วัดพุทธนิมิต โคโลราโด สปริงส์ Wat Buddhimit of Colorado Springs

Letter of Intent  
PCD File No: PPR2416  
Zone: RR-5

Wat Buddhimit of Colorado Springs plans to erect 36' X 72' temple  
located at 7525 Falcon Meadows Blvd. Peyton, CO 80831 Parcel No. 5302001017

SHEET NUMBER:  
**100**

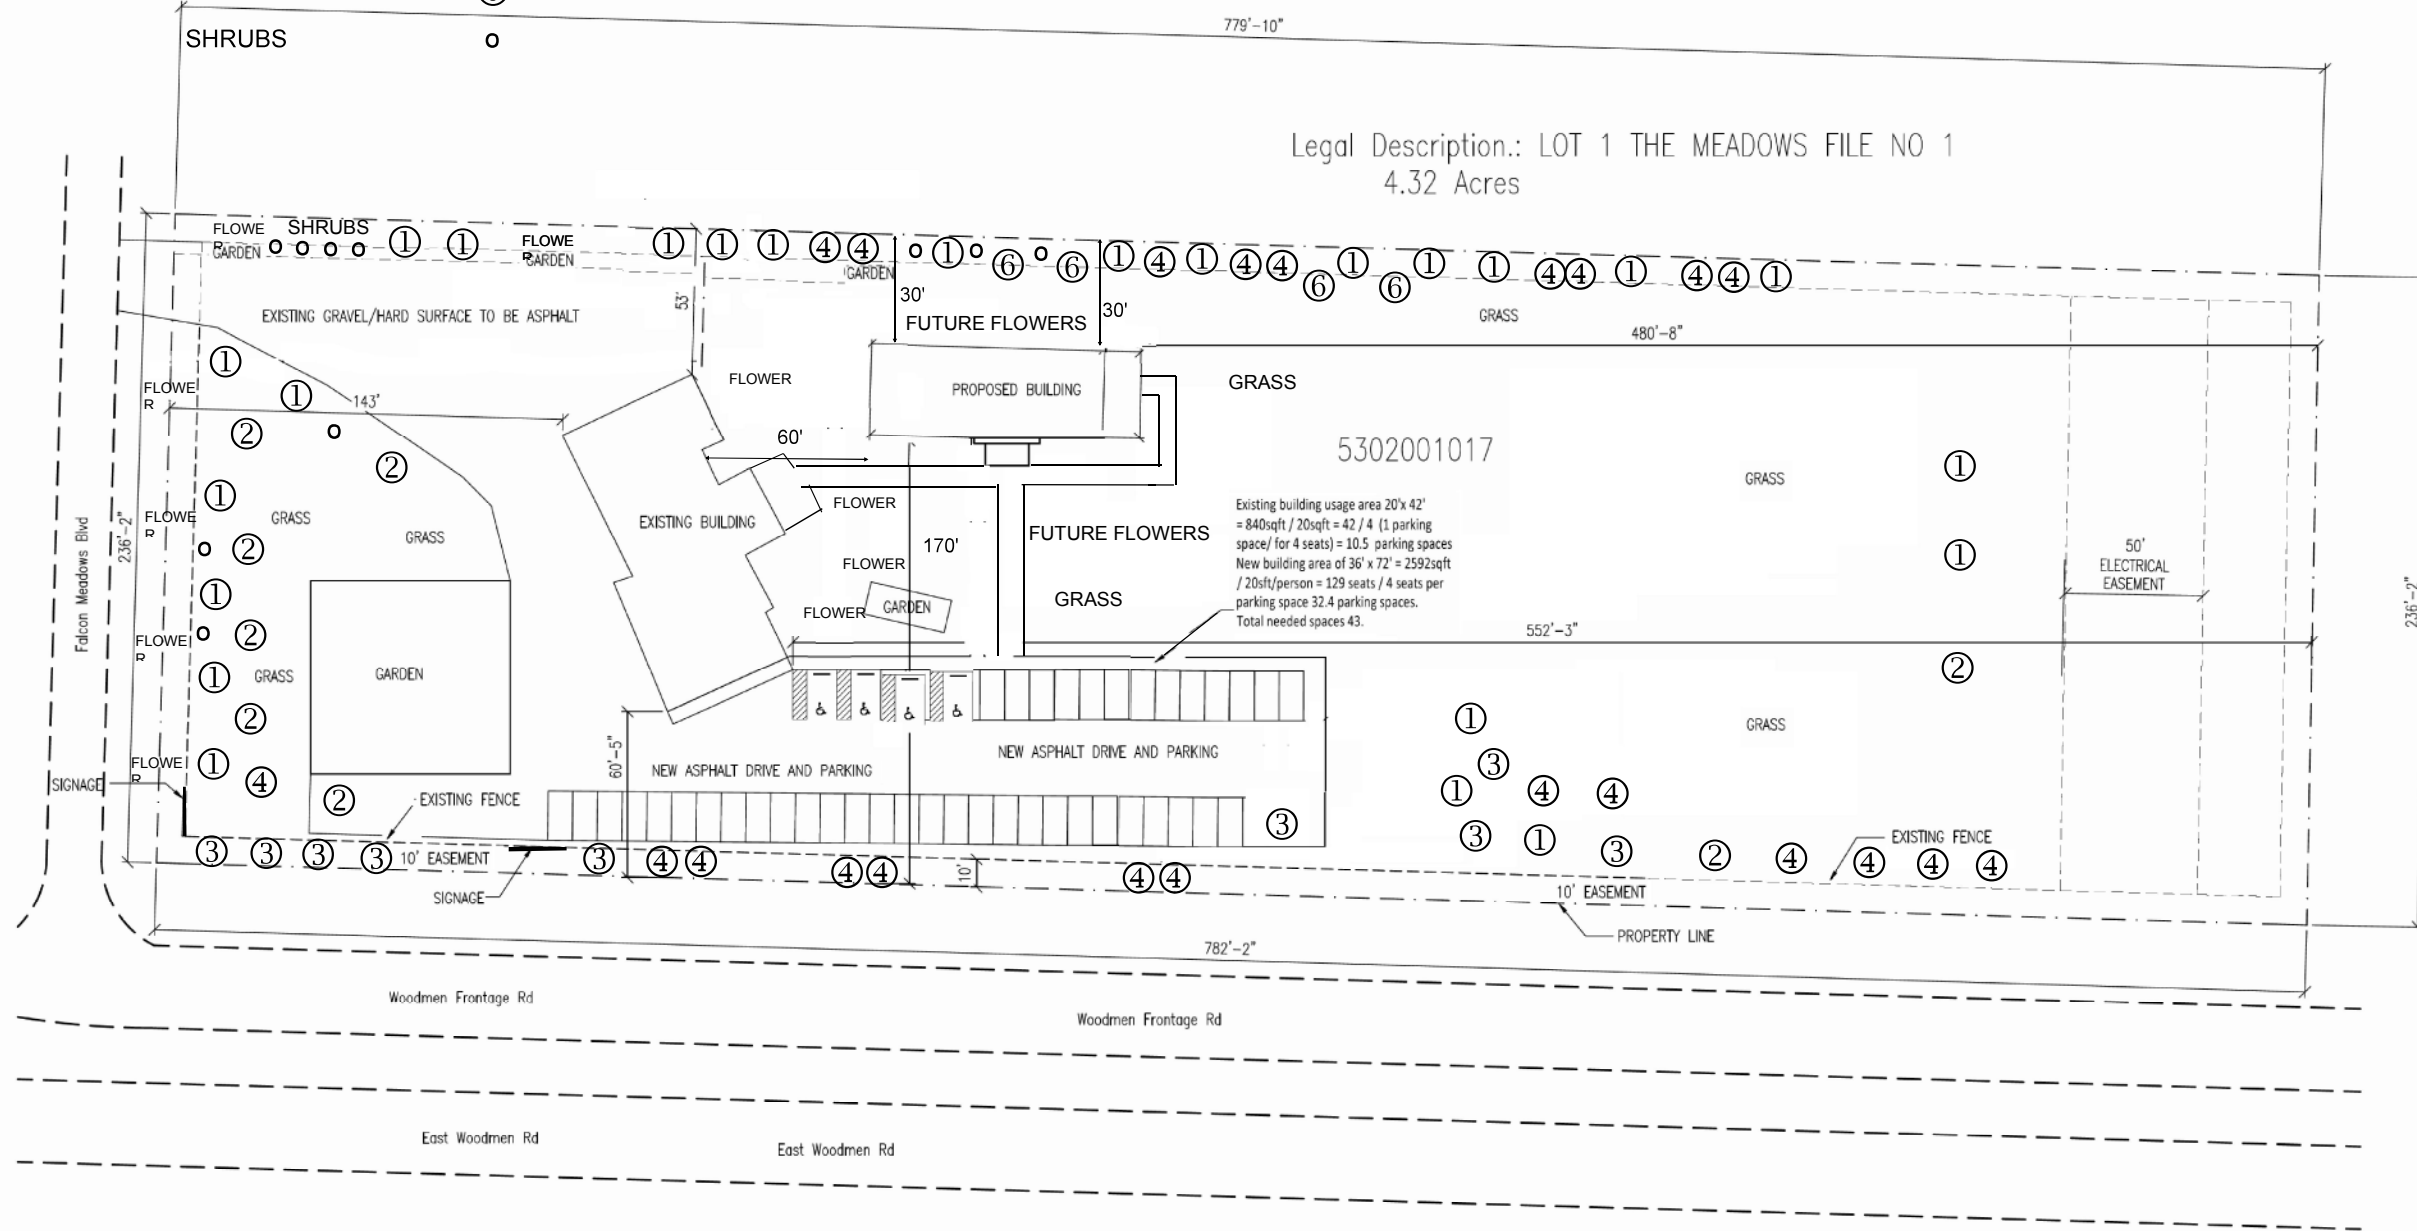
Please discuss how utilities, such as  
electrical, will be provided.

Please discuss how many acres will  
be disturbed to build the new  
building, new asphalt driving and  
parking. A drainage letter may be  
required depending on how many  
acres to be disturbed.

Please discuss how downstream  
drainage system will be impacted by  
project

Please state the total anticipated  
proposed soil disturbances (not just  
impervious surfaces), including  
grading needed for proposed  
buildings, driveways, parking areas,  
gardens, landscaping, etc.
